Application number: 2023/92266	
What is the application for?:	Demolition of part of boundary wall to create entrance for off street parking (w
Address of the site or building:	50, Birkby Lodge Road, Birkby, Huddersfield, HD2 2BG
Postcode:	HD2 2BG

Proposed Site Layout 1.100

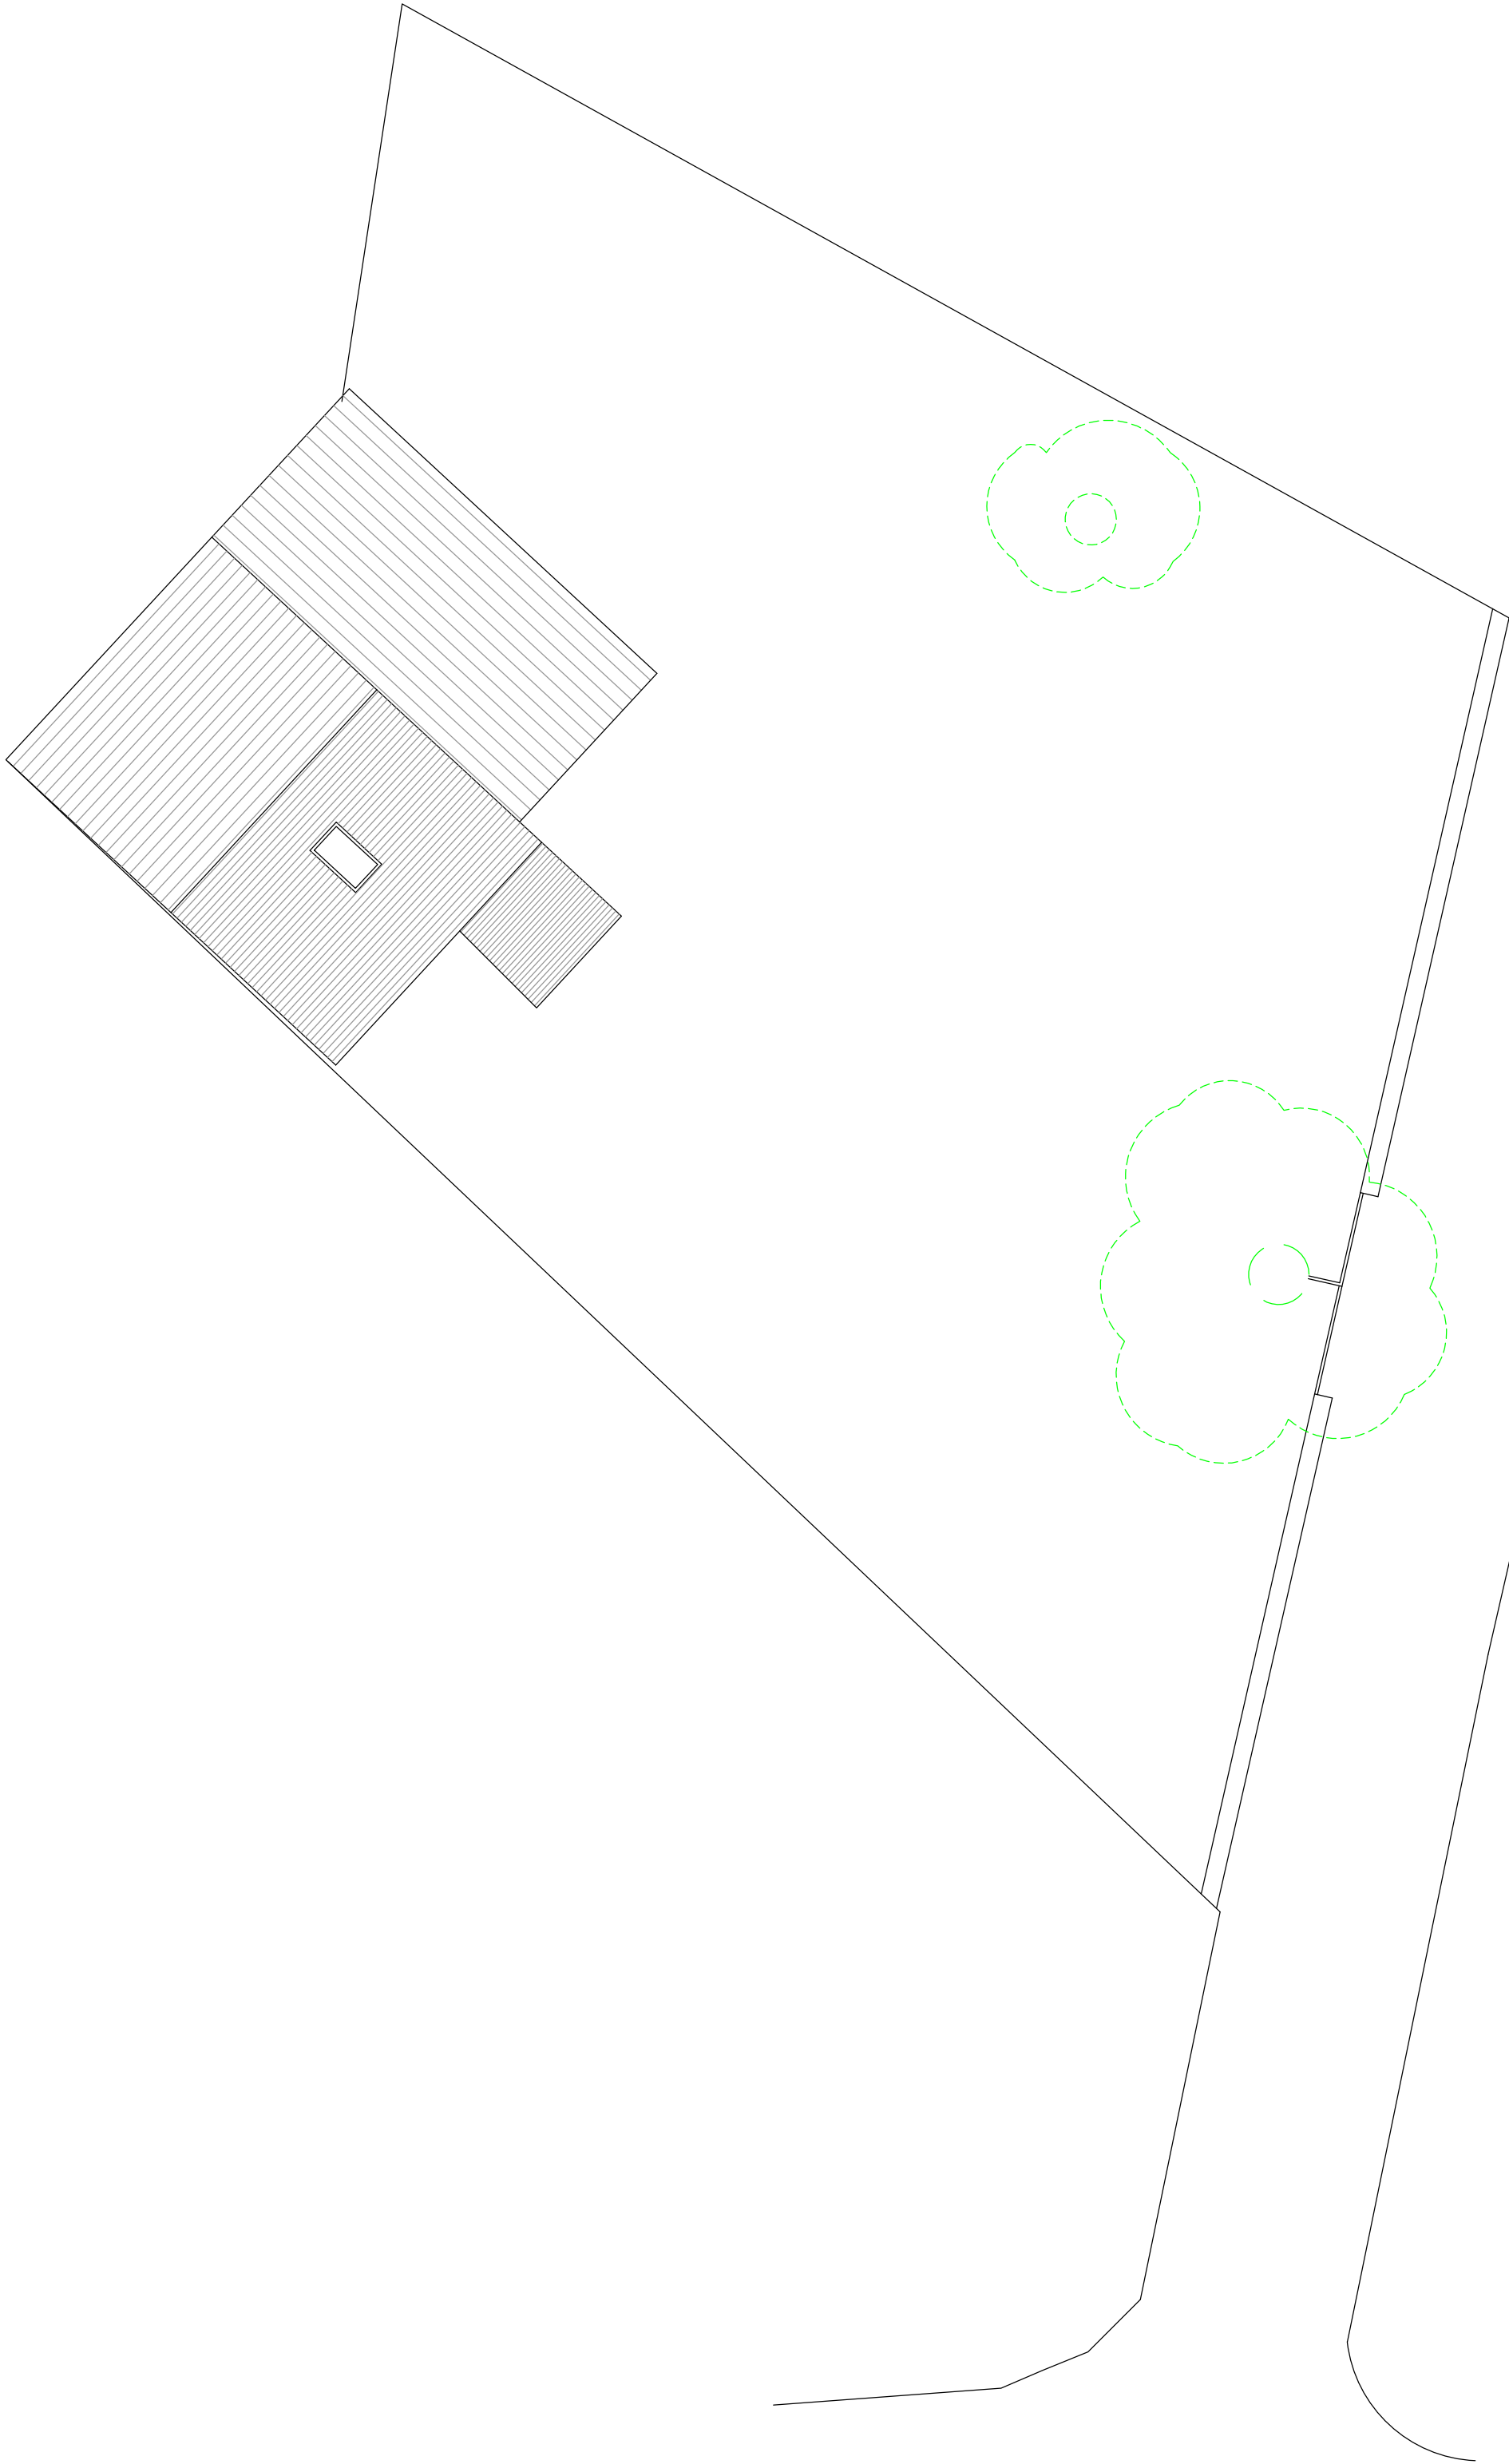
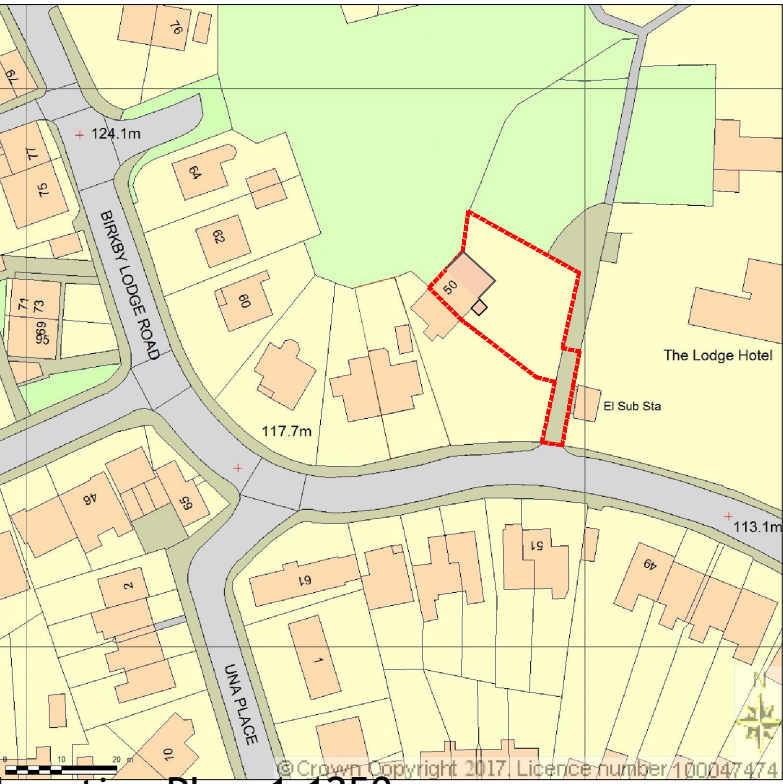
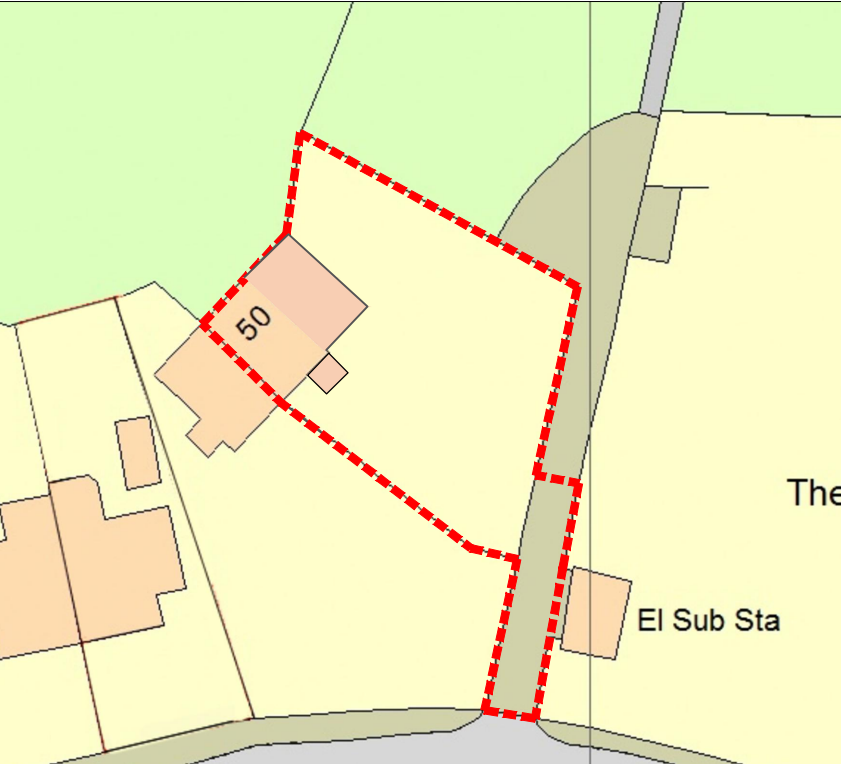
Type of comment: An objection	
Do you wish your comments to be published on the website anonymously?	Yes
I strongly object to the proposed idea of using a narrow well used public footpath has a driveway.i use this footpath several times a day.Its a safer walk for all including children too and from local schools otherwise it means walking on pavements with cars parked on.on very busy roads. So I would conclude that in allowing this so one house to gain a driveway it would seriously impact on a large amount of local people !! And please remember it's a footpath !!
